SHOALHAVEN CITY COUNCIL

**COUNCIL's SUBMISSION to the applicants RESPONSE to
SUBMISSIONS REPORT**

MAJOR PROJECT APPLICATION CONCEPT PLAN MP09_0088

Tim Fletcher
Director Planning and Development Services Group.
14 February 2014

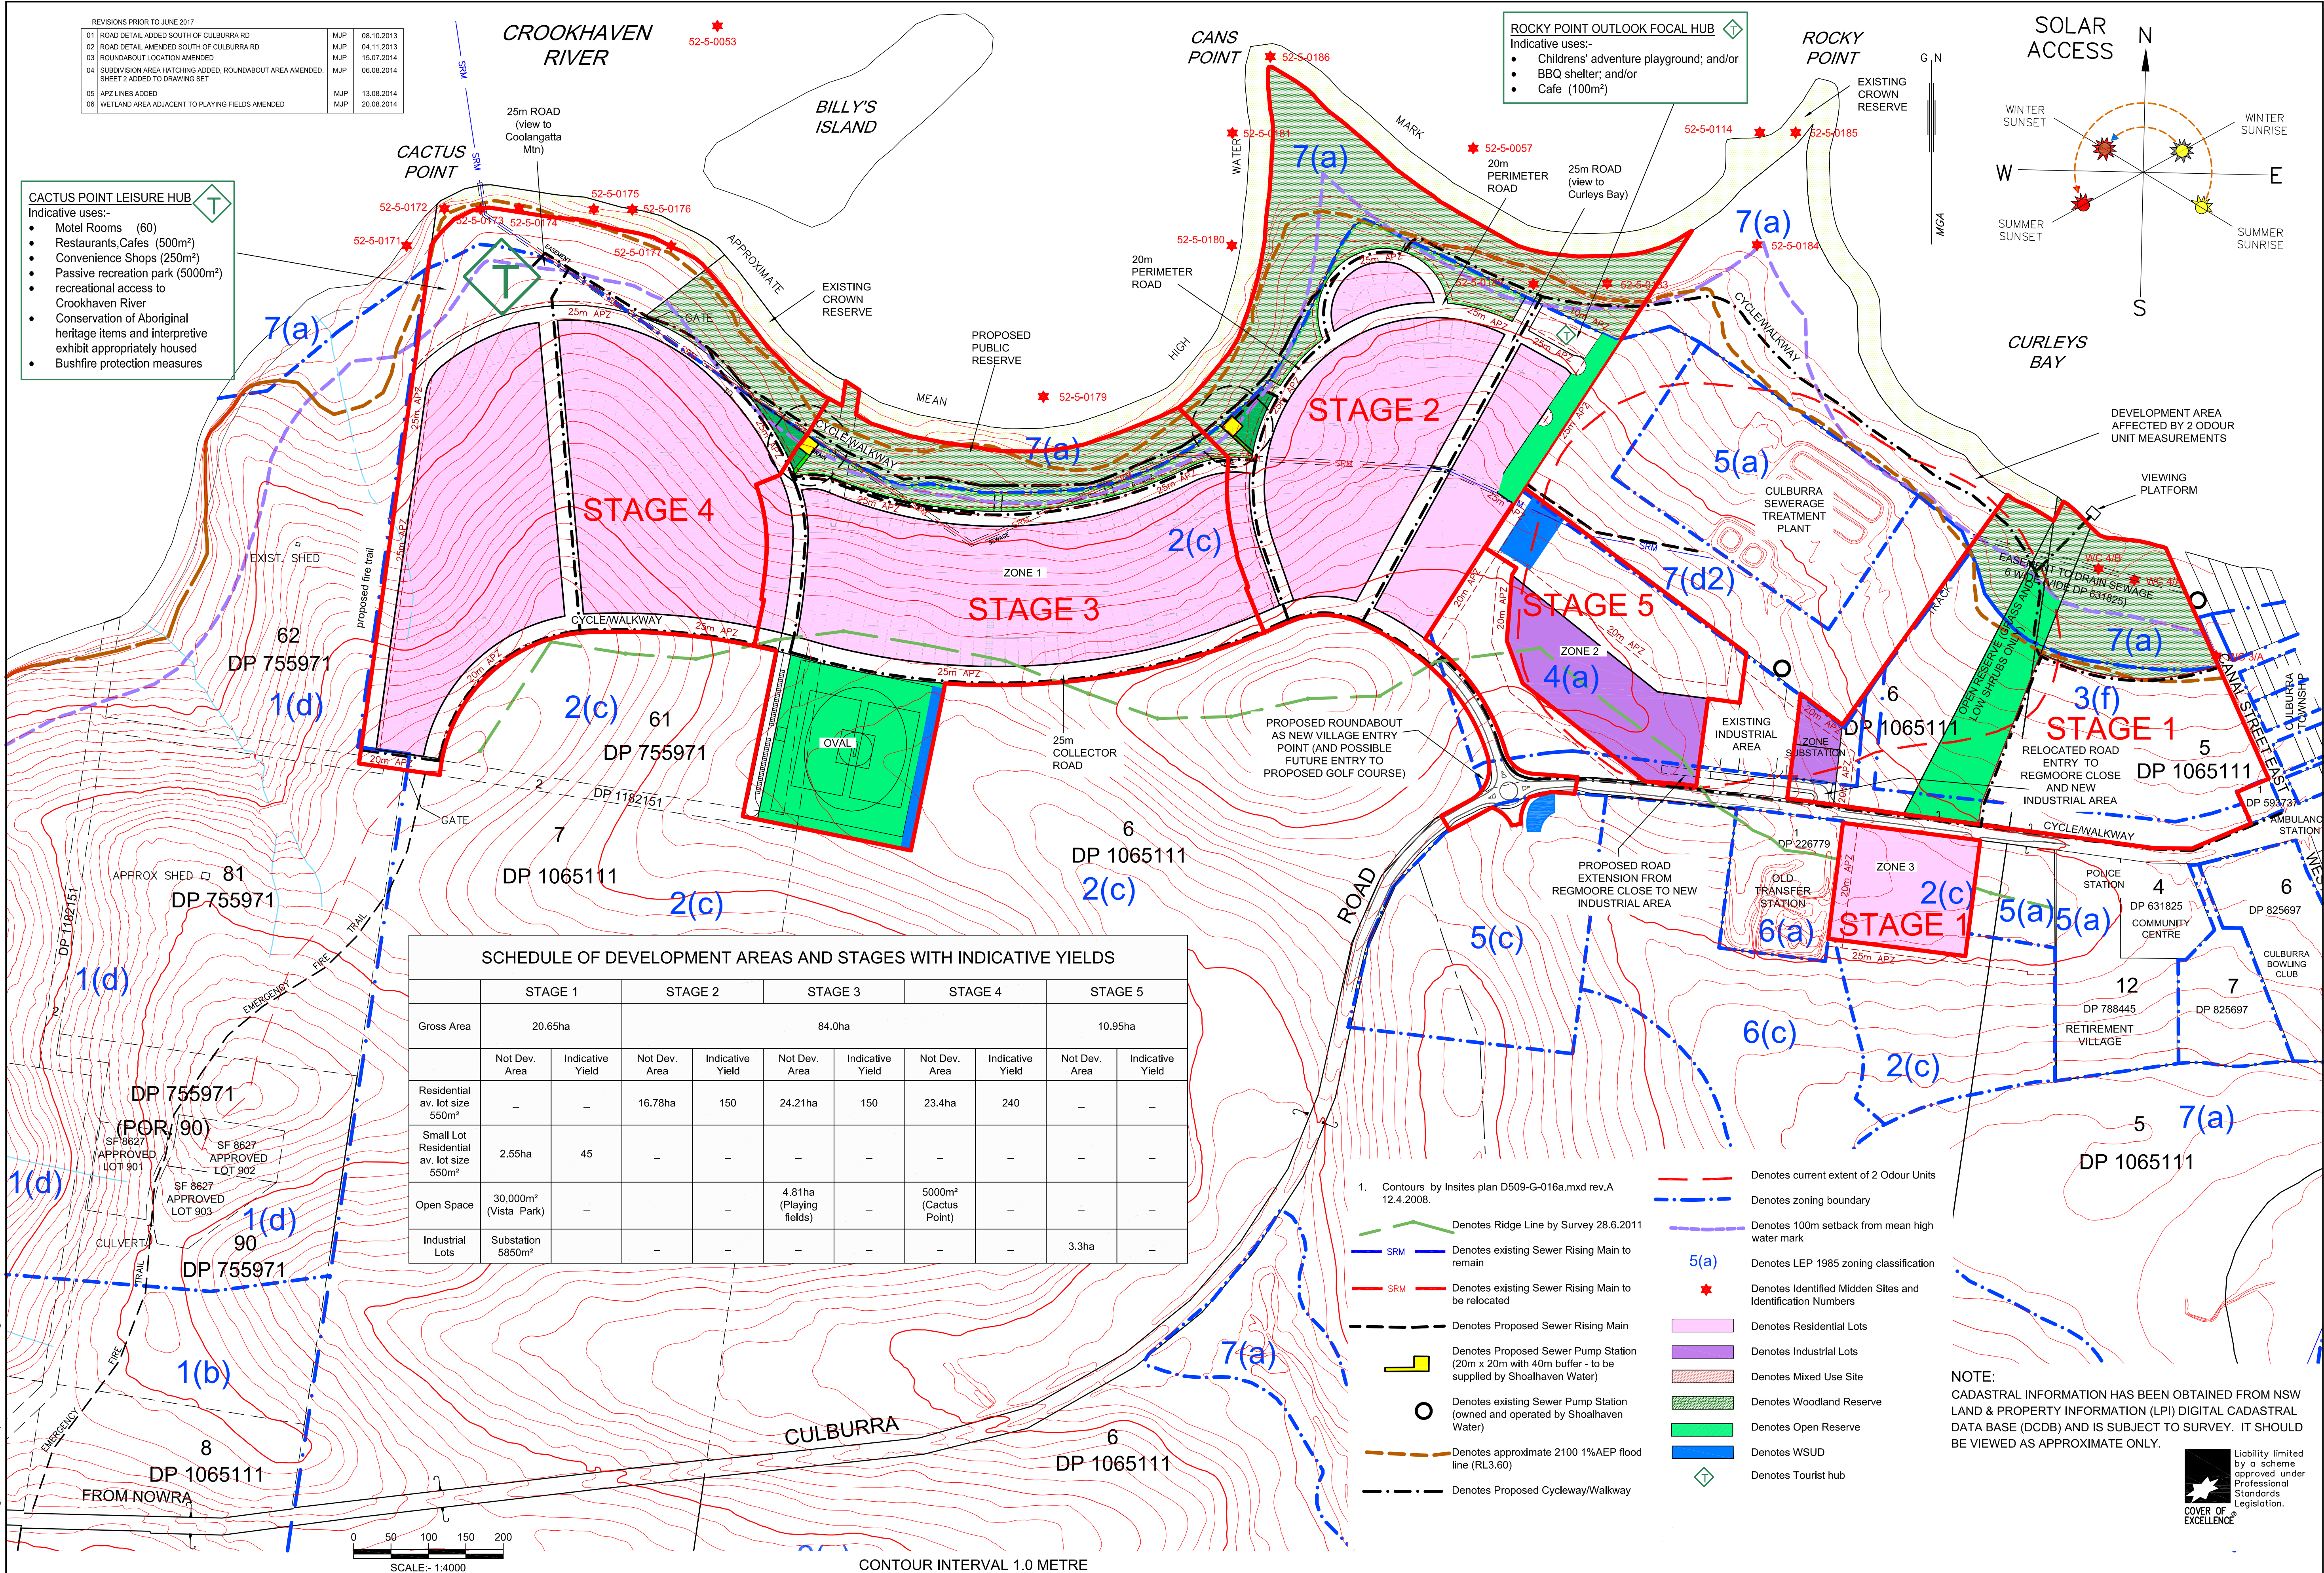
It is noted in the amended layout plan 25405-37 that:

- (a) There are three "viewing platforms" within the waterway and there is limited justification included in the RTS. Such structures could adversely impact the waterway and its vegetation and therefore require further investigation.
- (b) The plan does not indicate what the "blue shaded" areas represent. They appear to be a buffer but are not described. This needs to be included in the legend so it can be commented on and considered by the Department.
- (c) The plan relocates the electricity substation following discussions with the electricity authority and this is acceptable with landscape screening .

- (d) The plan east of the industrial area adds a “hotel site” and “community uses” area without explanation in lieu of the previously termed “future development zone”.

The strategic overlay previously mentioned could put such land use in context, however in absence of this information the previous designation of “future development” should be reinstated to avoid latter assumptions of potential uses.

REF. No.
26068-02
REVISION
0

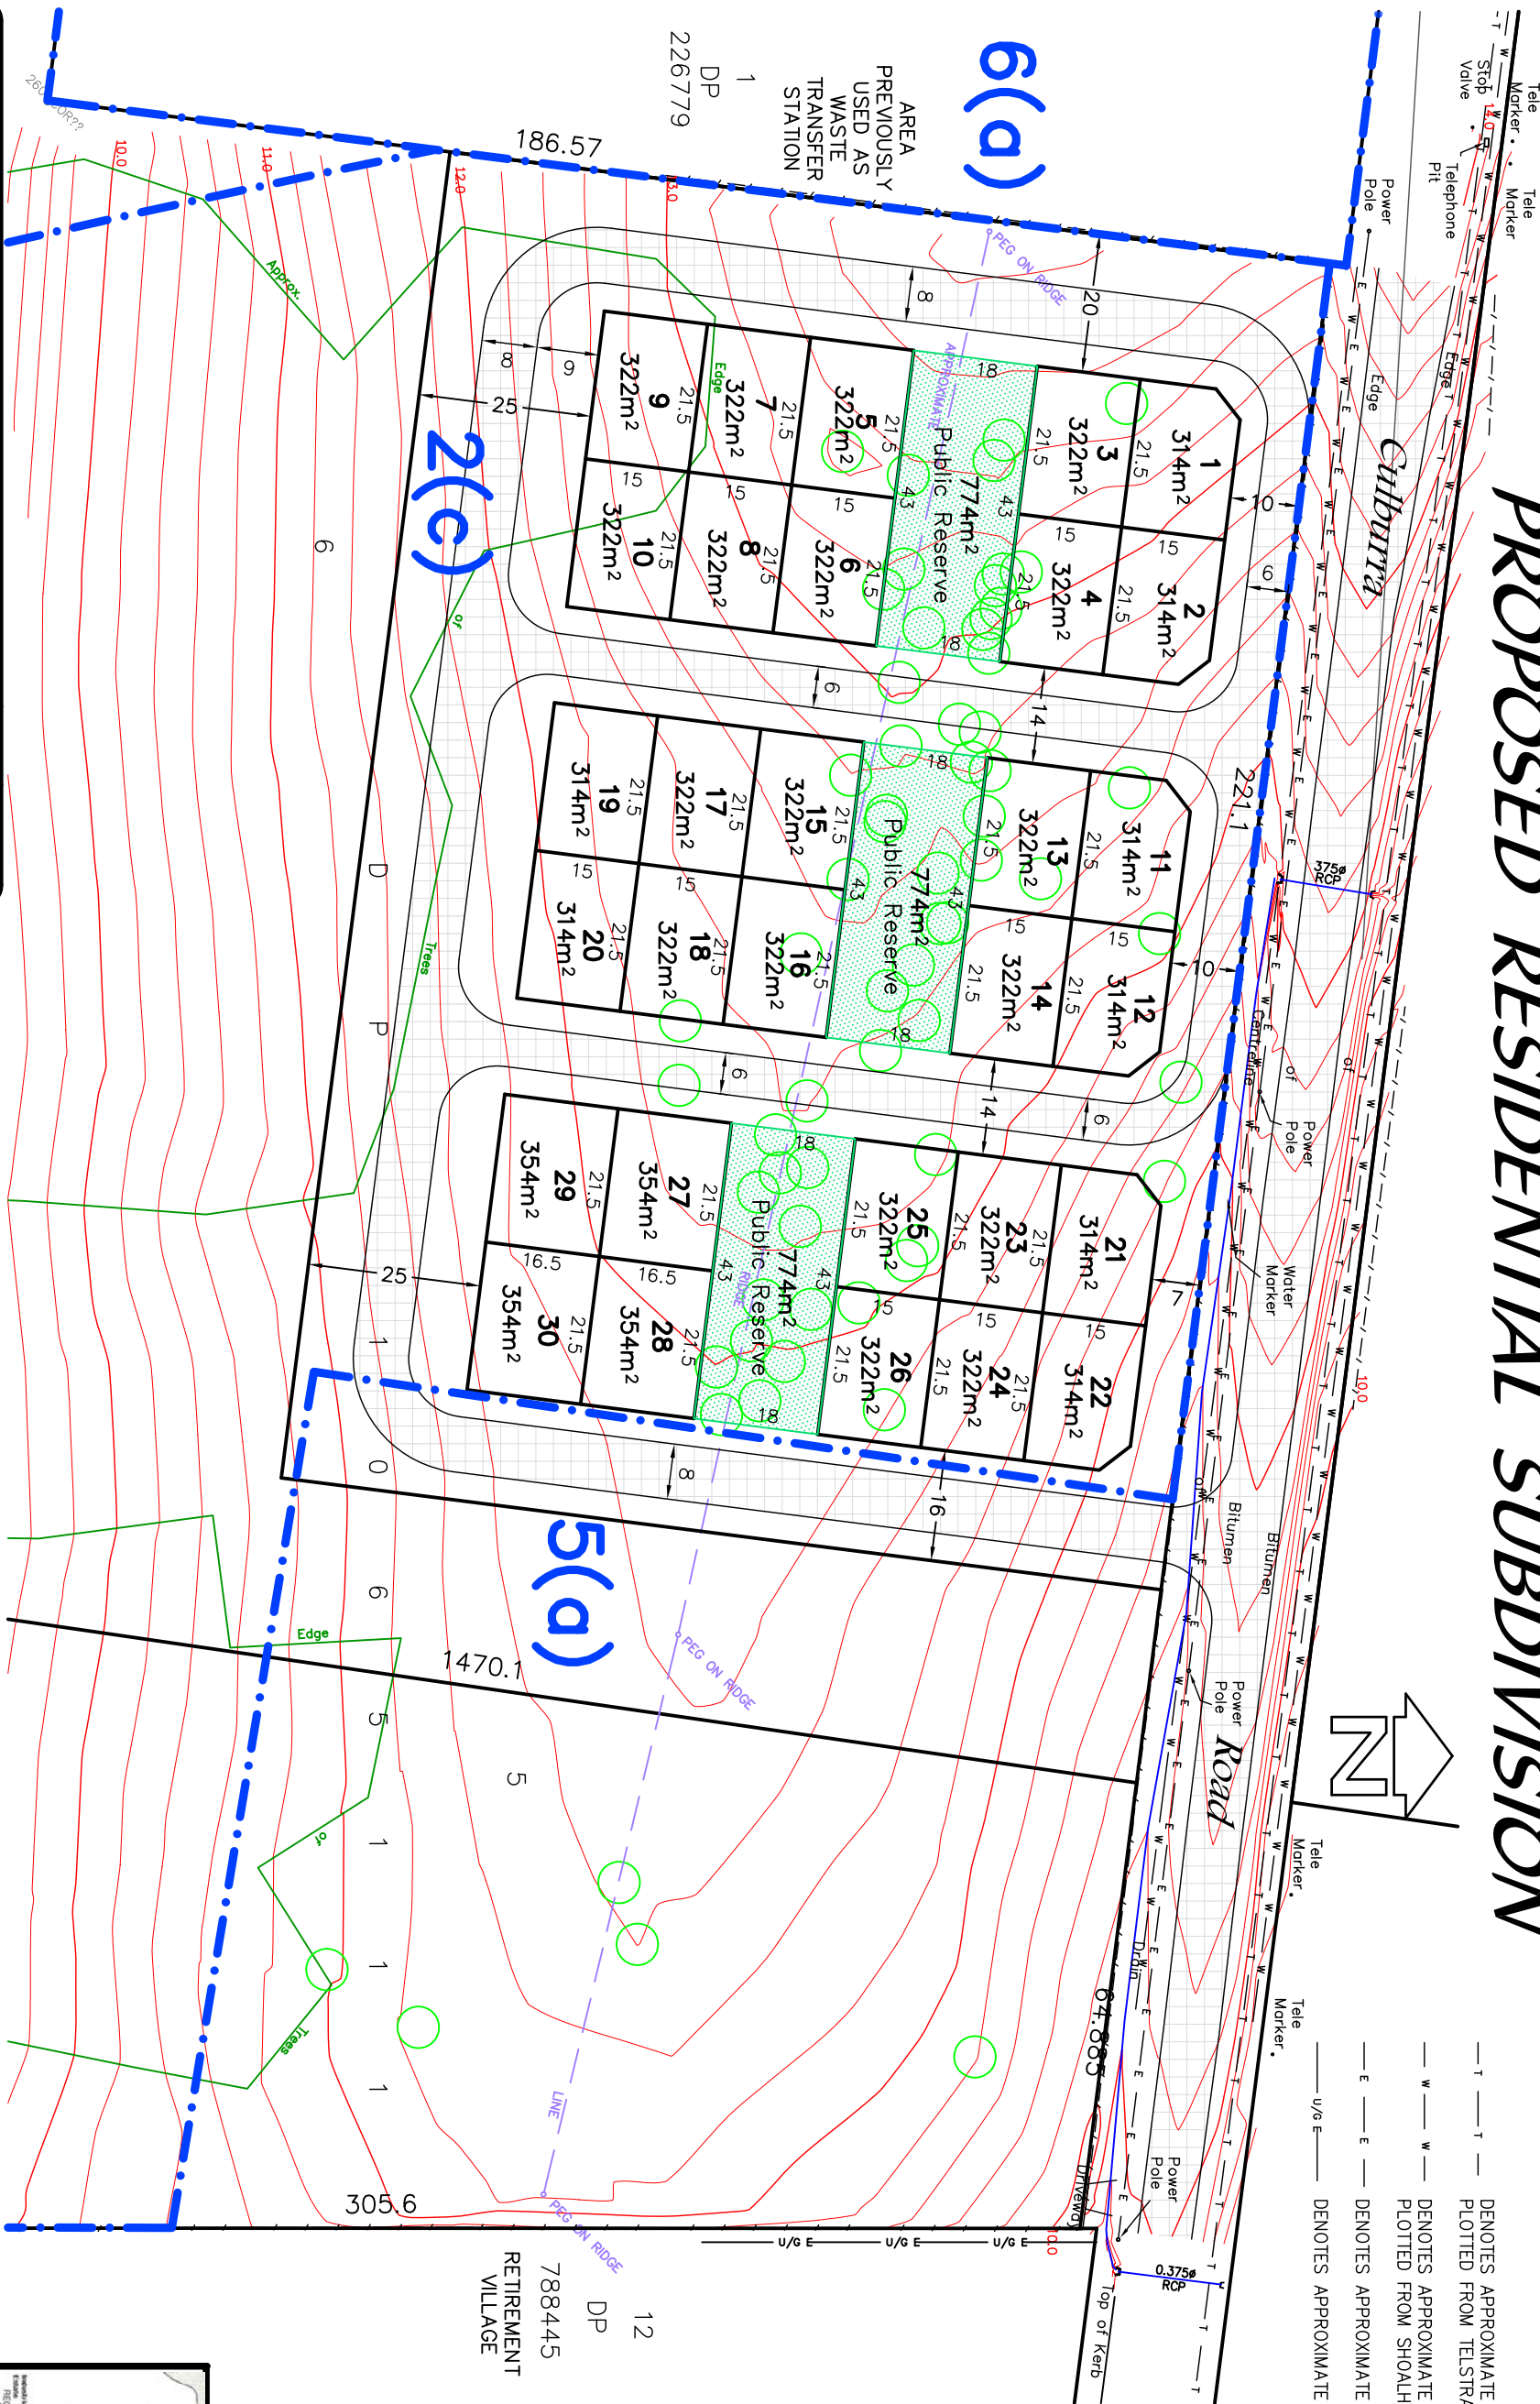
(a) Stage 1 – small lots south of Culburra Road:

- (i) The use of the public land to provide a required APZ is not supported.
- (ii) The lot areas are less than the standard lot within DCP100 without analysis and development guidelines as required for integrated lots.
- (iii) The small pocket parks are inadequate in area and are not acceptable as dedicated public reserve. (DCP 100 specifies a minimum area of 3000 m²). Smaller areas are a liability in maintenance and usability. Should the proposed subdivision be via Community Title the open space areas may be within the community use land and the responsibility of a management plan.
- (iv) A buffer that separates the main Culburra Road and the internal service road is required to avoid an apparent wide single road reserve.
